Reference P/25/11 - 3 Old Barn Close Mill Farm Estate PO21 3UG

We wish to protest against the proposed Conservatory Extension by Mrs. Chown.

sheet 1 of 2

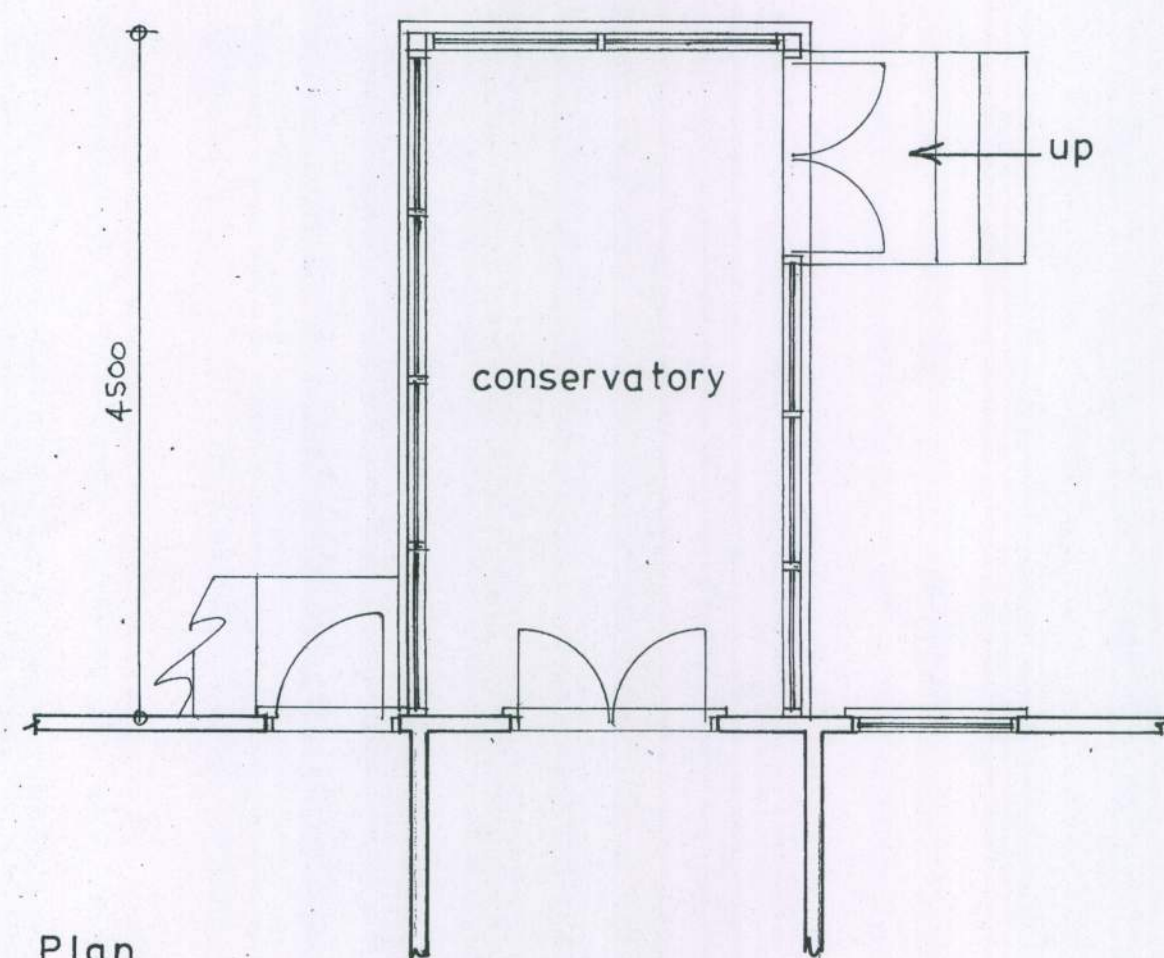
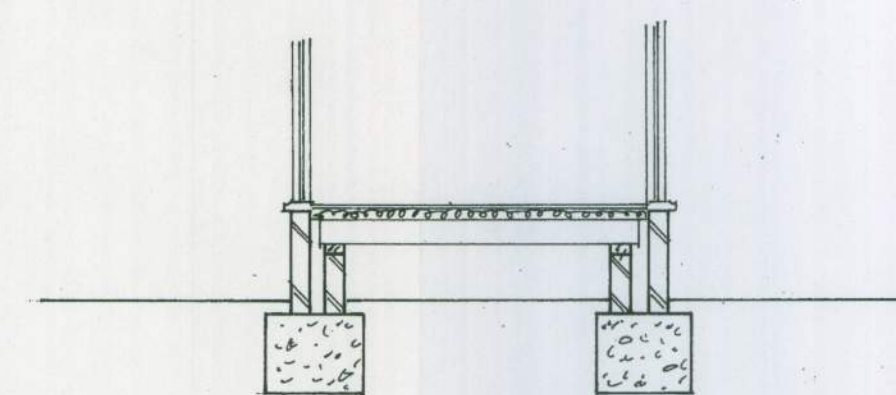
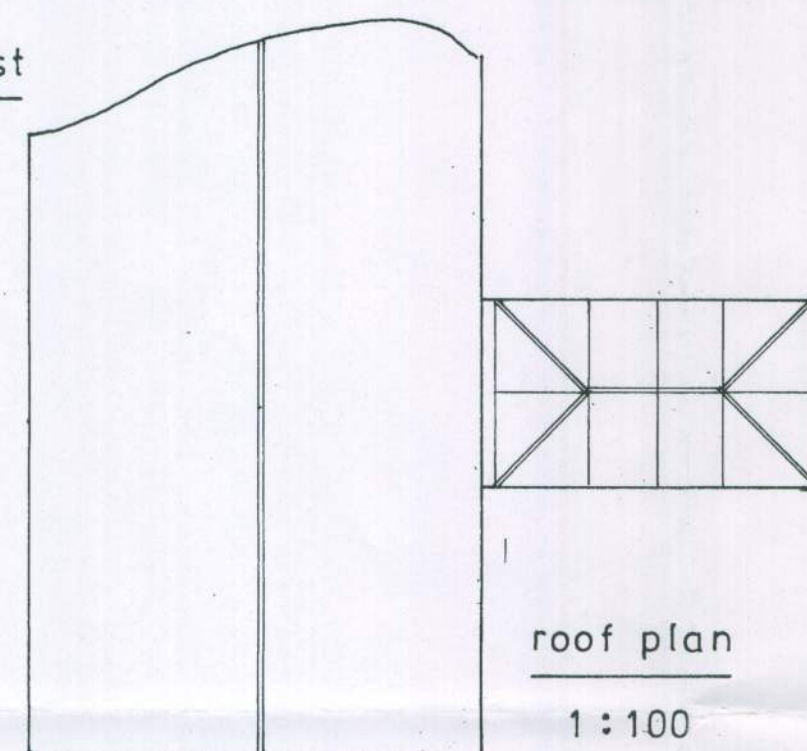
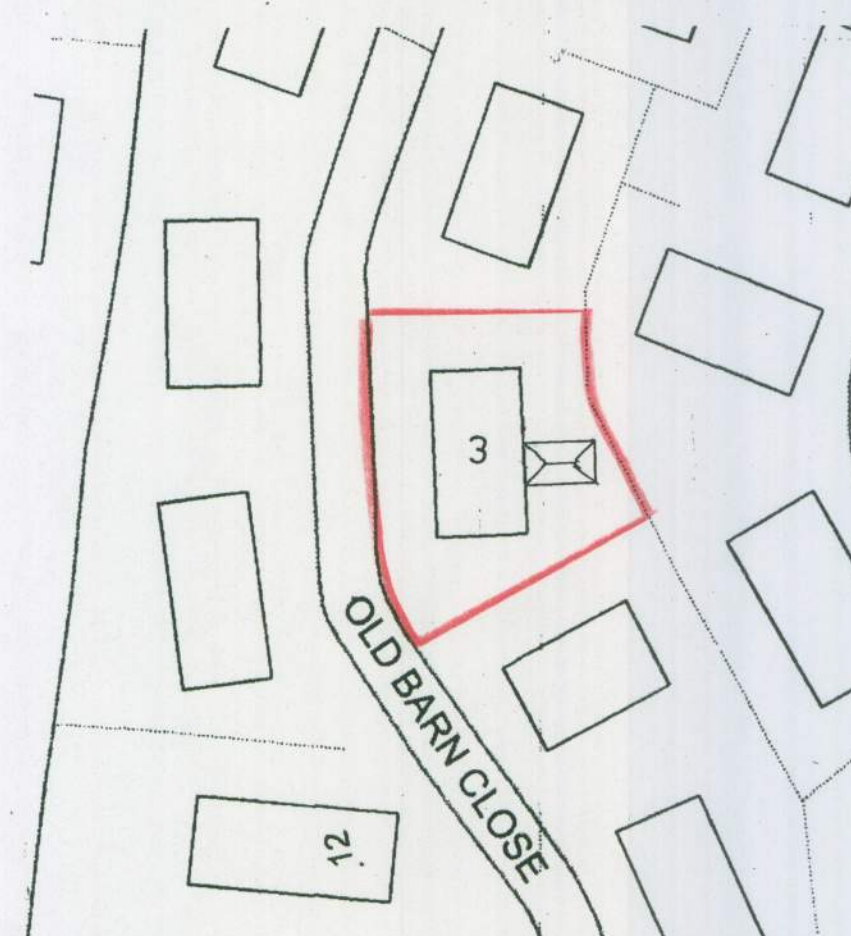
Our main objection is that the depth of 4.5m from her Park Home would bring the Conservatory to 50cm from our Boundary fence. With the addition of the floor height to the Conservatory of 70cm above ground level and the height of 3.1m plus roof will spoil the privacy that we have, and we feel it will encroach on us

On Mill Farm Estate extensions to properties with small gardens are placed 2.5m depth and width to suit. We would have no objections to this layout, as it would be more neighbour friendly.
